Appeal Decision

Appeal Ref: APP/R5510/D/24/3336479

12 Chiltern Court, Widmore Road, Uxbridge, Hillingdon, UB8 3BJ

- The appeal is made under section 78 of the Town and Country Planning Act 1990 against a refusal to grant planning permission.
- The appeal is made by Mrs Balwinder Kaur Pank against the decision of the Council of the London Borough of Hillingdon.
- The application Ref 78157/APP/2023/2095, dated 14 July 2023, was refused by notice dated 3 November 2023.
- The development proposed is single storey rear extension.

PROPOSED GROUND FLOOR PLAN

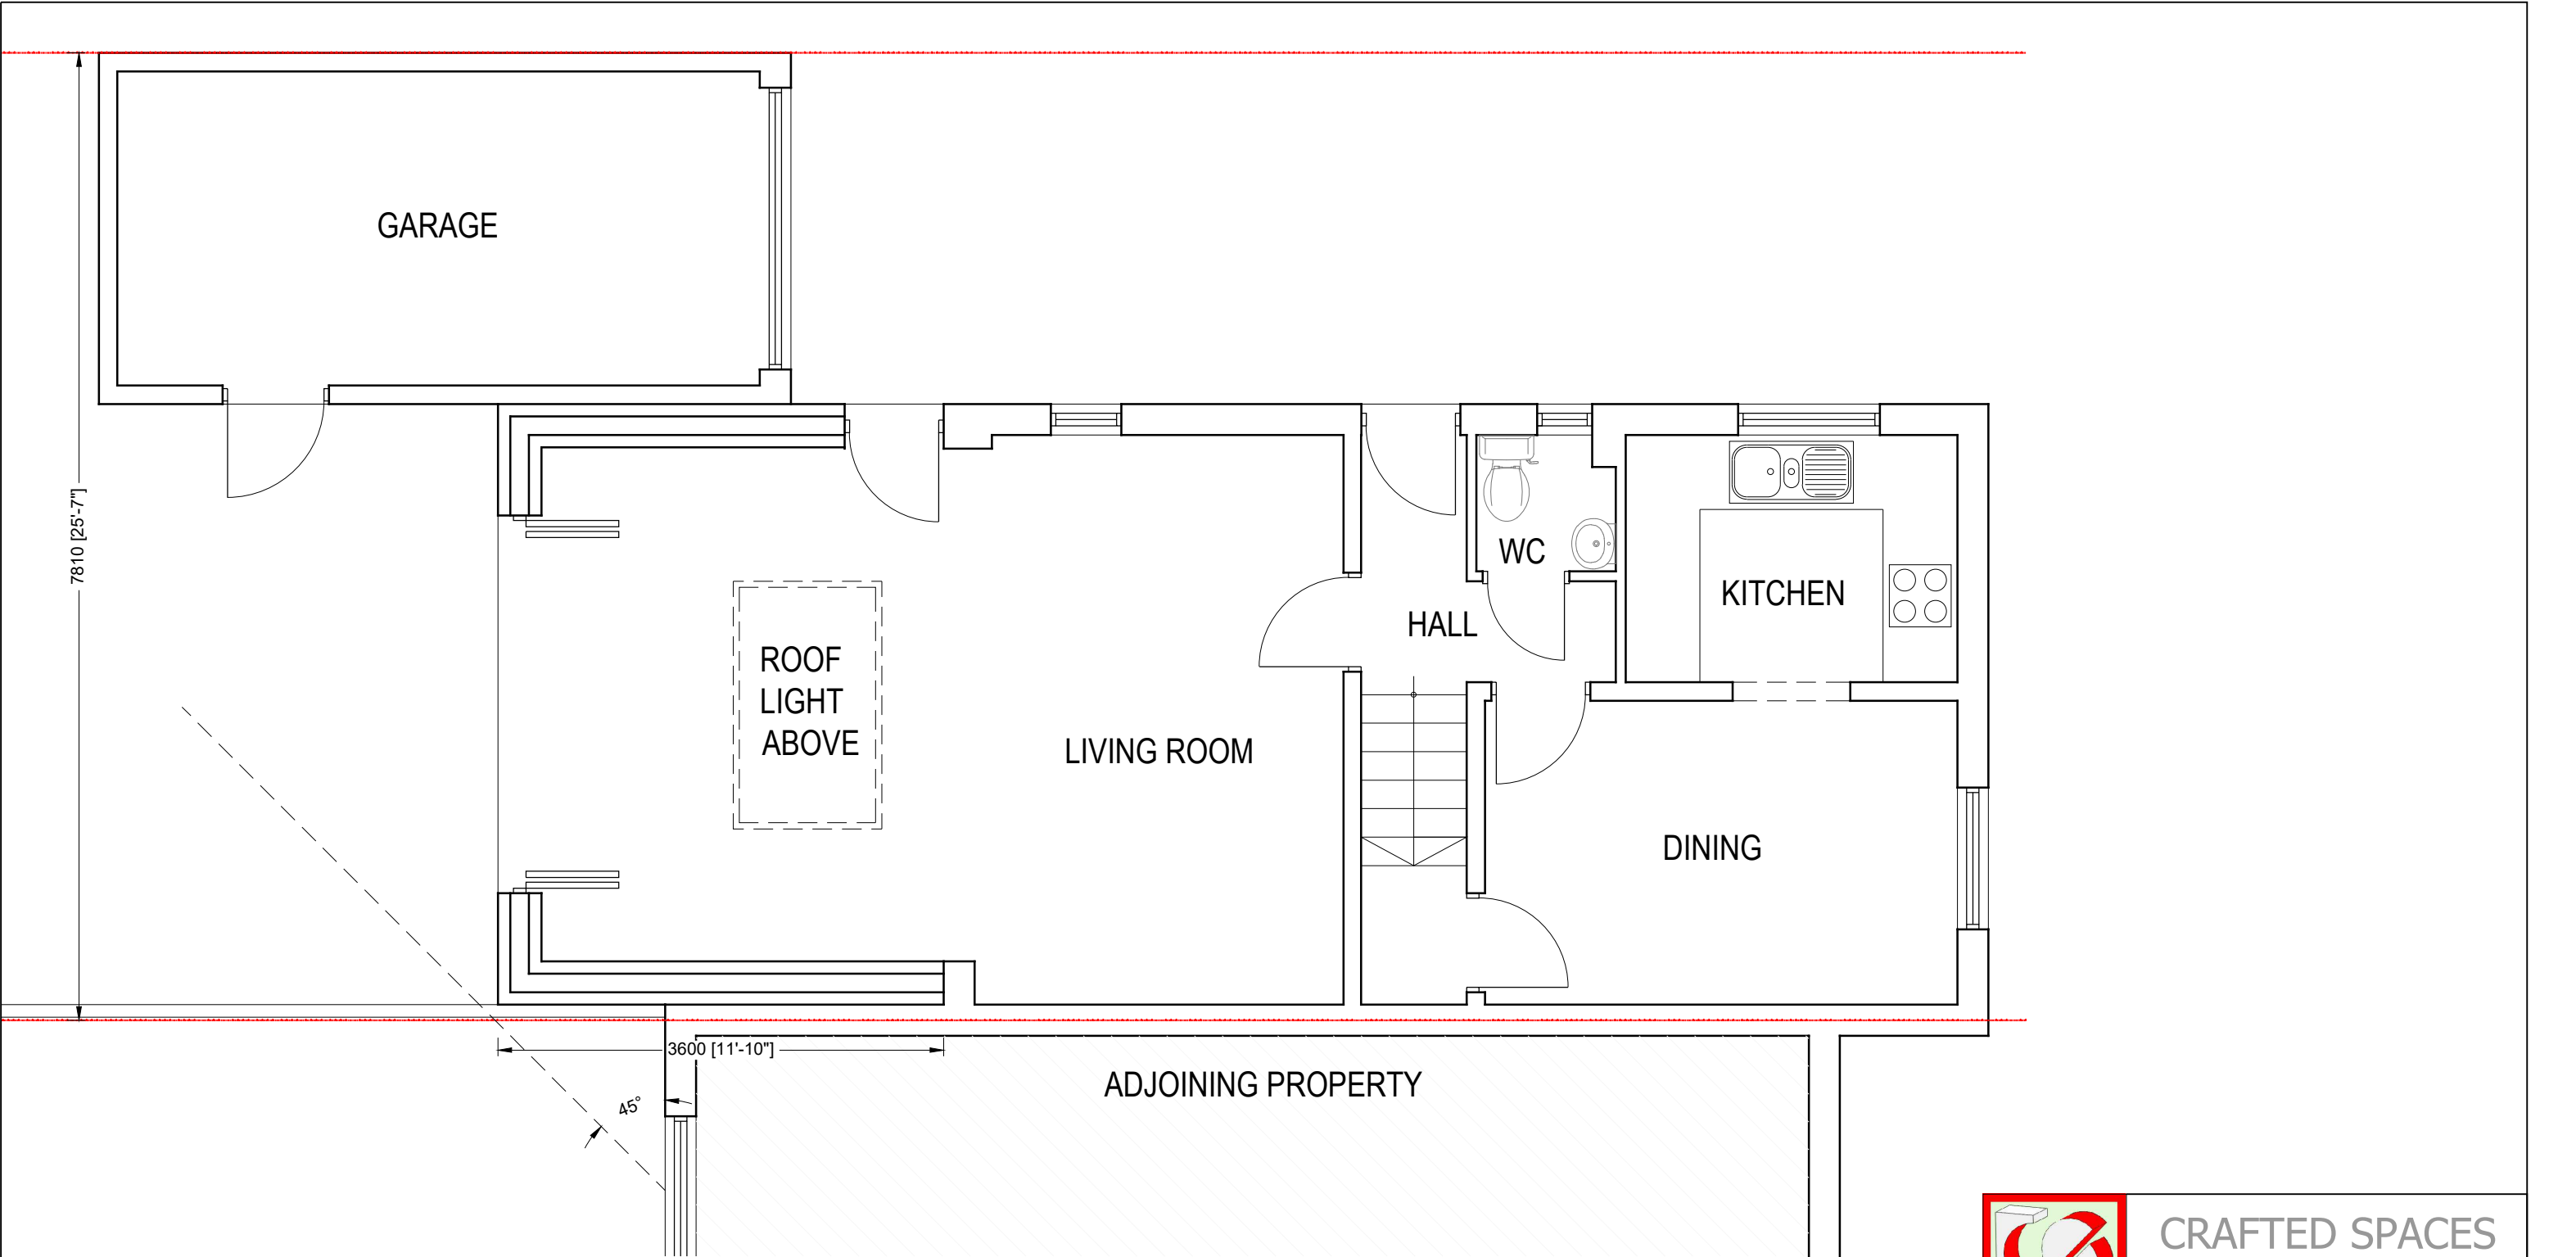
5. The existing house is modest in scale, with two small reception rooms on the ground floor separated by the stairs to the upper floor. I consider that the additional internal space provided by proposed single storey extension would improve the living conditions of the occupiers by providing a larger living room with a south facing aspect.

6. The proposal would reduce the private outdoor amenity space to approximately 42sqm, which falls below the minimum recommended in local plan policy DMHB18. However, this applies to all new residential development and conversions and there is no suggestion that this is applied to extensions to existing dwellings. Policy D6 of the London Plan requires private outside space to be practical in terms of its shape and utility.

7. I consider that the amount of private space remaining at the rear of the house, although relatively small, would be adequate for the occupiers in terms of its regular shape and utility, particularly as it faces south.
